Submission – Objection

Apsley Battery Energy Storage System – Modification 1

Application reference:	SSD-35160796-MOD-1
Applicant:	Energy Storage Project No 3 Pty Ltd
Site:	9010 Mitchell Highway, Apsley NSW 2820
To:	NSW Department of Planning, Housing and Infrastructure (Energy Assessments)
Submitted by:	Michael Burrough
Address:	PO Box 316, Wellington NSW 2820
Interest:	Local resident
Date:	19 June 2026
Position:	OBJECT

Figure 3: Indicative route for heavy vehicles

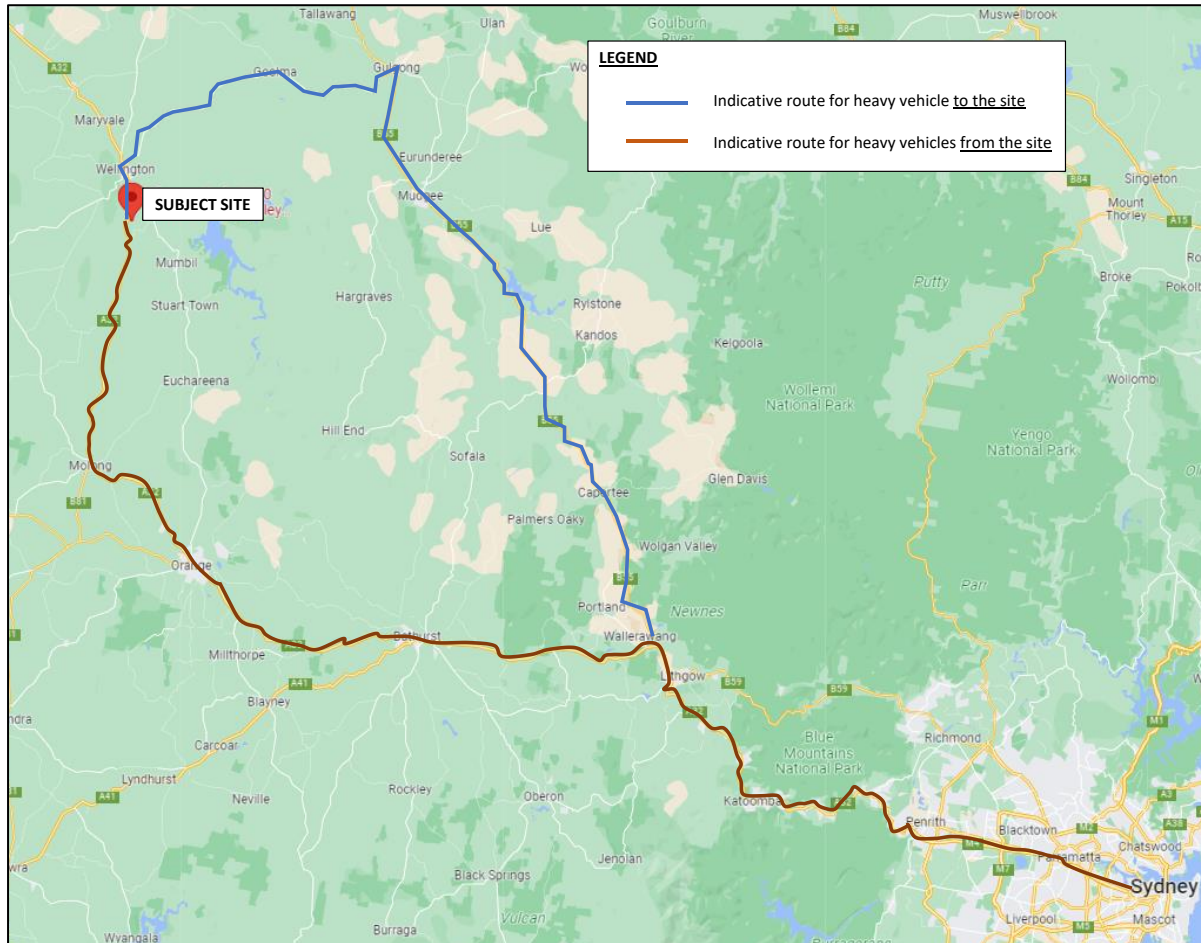
- **The OSOM route is not settled or disclosed.** The report assesses two alternative origins (Port of Newcastle and Victoria) and states only that one will ultimately be used, to provide flexibility for procurement. Affected residents cannot assess the impact of escorted oversize movements

when the actual route, timing and frequency are left open. A desktop route survey is not a substitute for a committed, disclosed route.

Figure 4-5: Bushfire Mapping

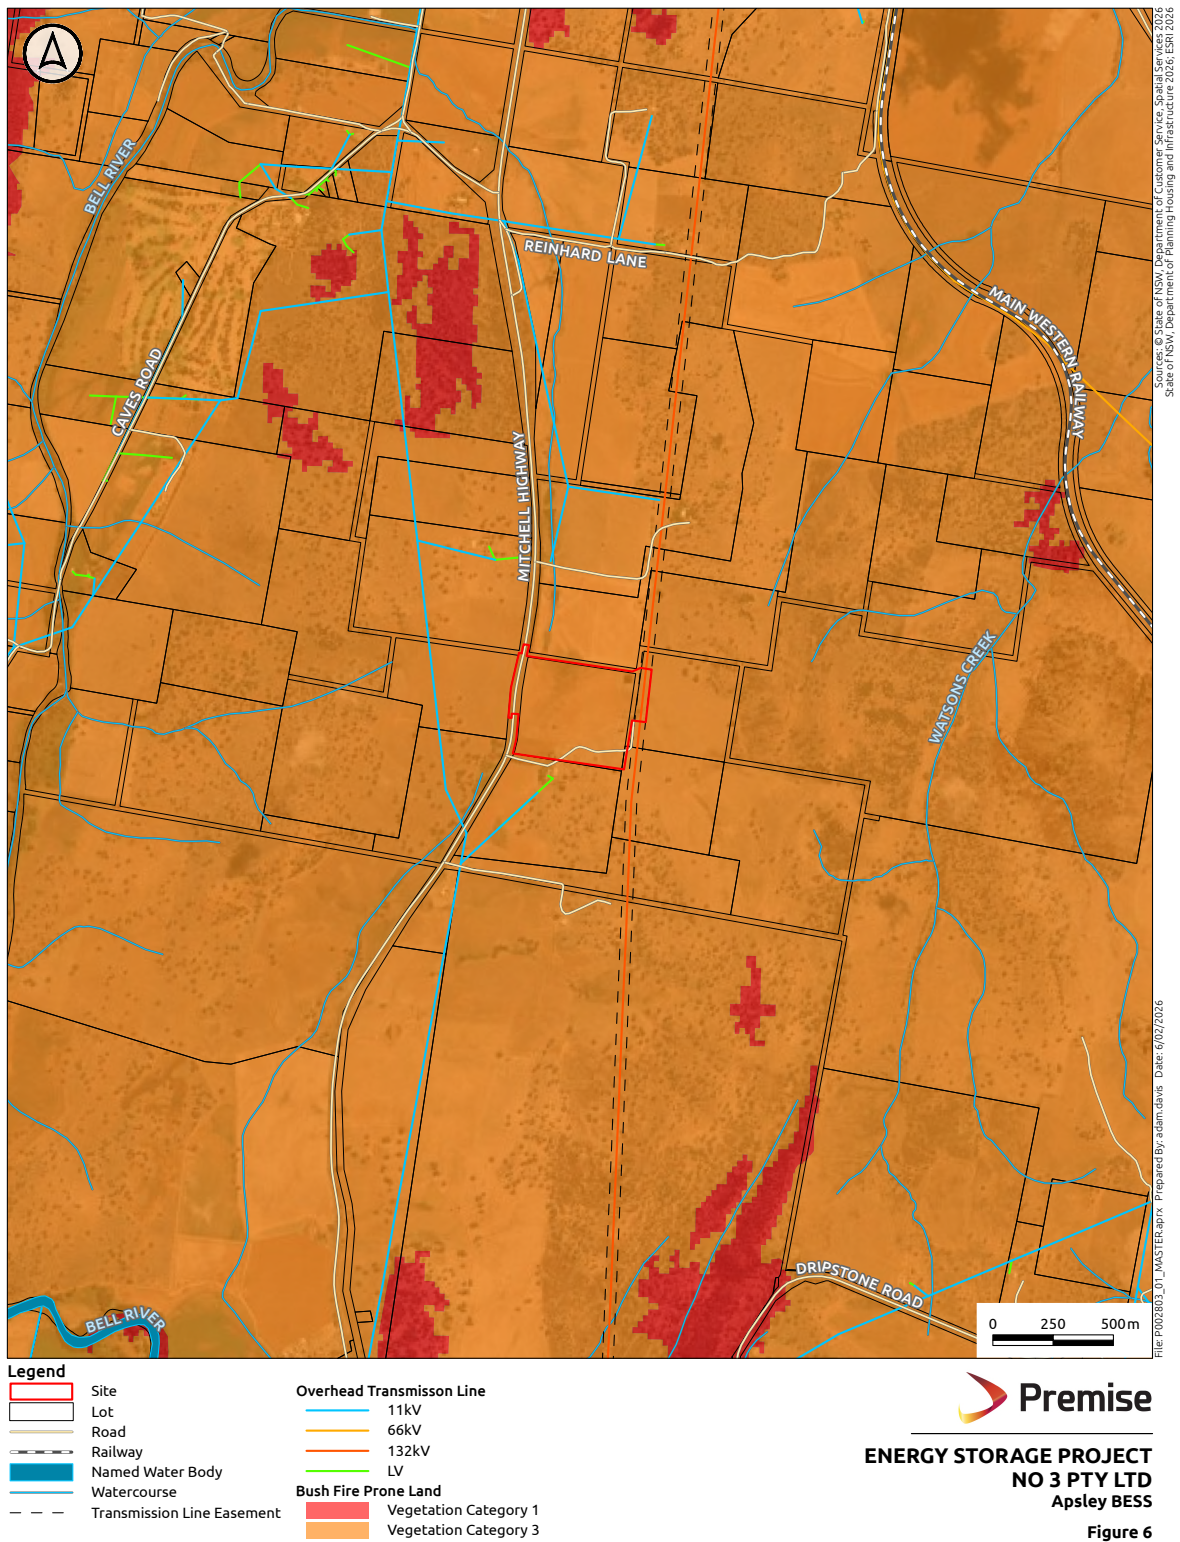
- **The site is now bush fire prone land.** The report itself states the site is now mapped as bush fire prone land (vegetation category 3) – a material change in site conditions since the 2023 approval. A doubling of stored energy on newly designated bushfire-prone land warrants a fresh, rigorous hazard analysis, not a review concluding ‘no additional risk’.
